**RE: Cadia Valley Operations – Cadia Hill Tailings Completion Submissions Report Addendum**

We refer to your email correspondence of 21 November 2019 and provide the following responses to issues raised by the Department of Industry Planning & Environment-Water (DPIE-Water) and Natural Resource Access Regulator (NRAR) on the Cadia Hill Tailings Completion Modification (the Modification).

Figure 11 Modelled Final Void Water Level

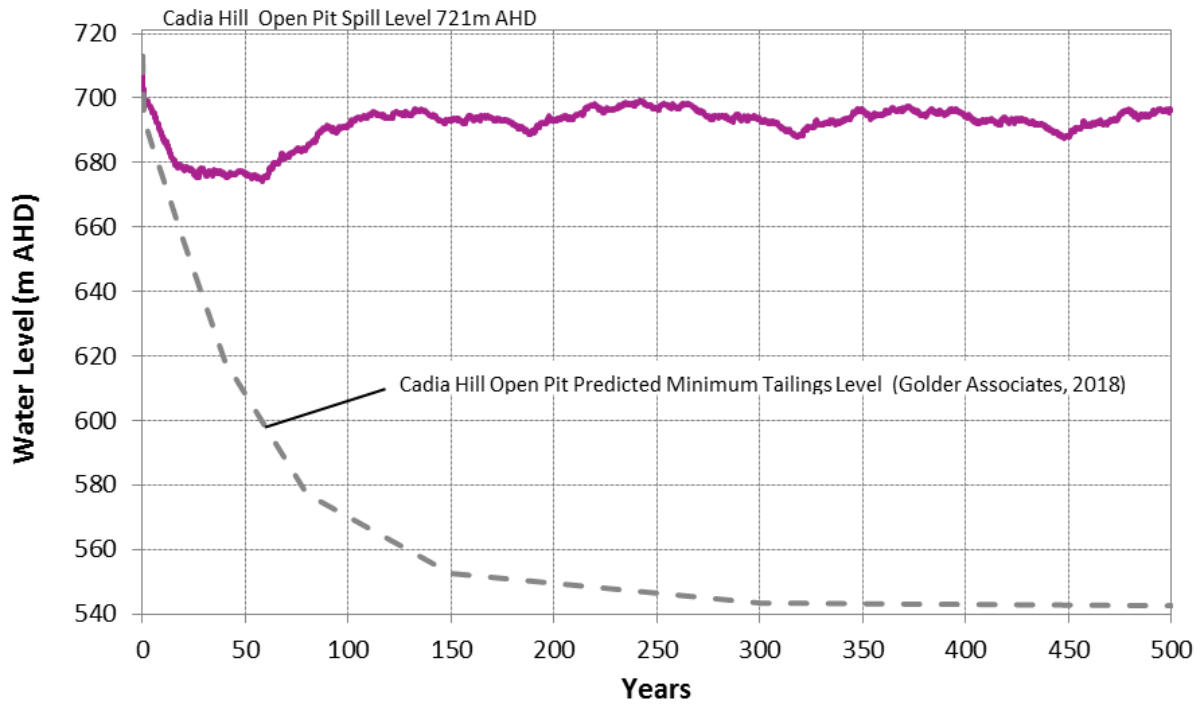
- *Provide references for climate sequence generation method used, or adopt stochastic methods consistent with the climate literature. All models reliant on this sequence may require updating.*
- *Provide details on the 'water-use reduction' methods (as stated in the EIS), if water supply is threatened through drought. Additional comments are provided in Attachment A regarding this recommendation.*
- *Quantify dam spill predictions for wet, dry and median years.*
- *Remodel streamflow including the culverts, to address the risk of localised flooding near culverts and crossings.*
- *Revise the Groundwater Assessment Report to include the water quality results from MB 95 monitoring bore in order to establish baseline conditions or ascertain any movement of tailings water from the pit.\**

- Climate sequence data used for the site water balance was sourced from the Bureau of Meteorology, as described in HEC (2019):  
*Daily climatic data used in model forecast simulations, as outlined in Section 3.0, was sourced from the SILO Data Drill. The Data Drill is a system which provides synthetic data sets for a specified point by interpolation between surrounding point records held by the Bureau of Meteorology<sup>4</sup>. Both rainfall and pan evaporation data were obtained from this source. Different rainfall data sets were obtained for different storage catchments – e.g. the mine site itself, Cadiangullong Creek Dam and Flyers Creek Weir.*
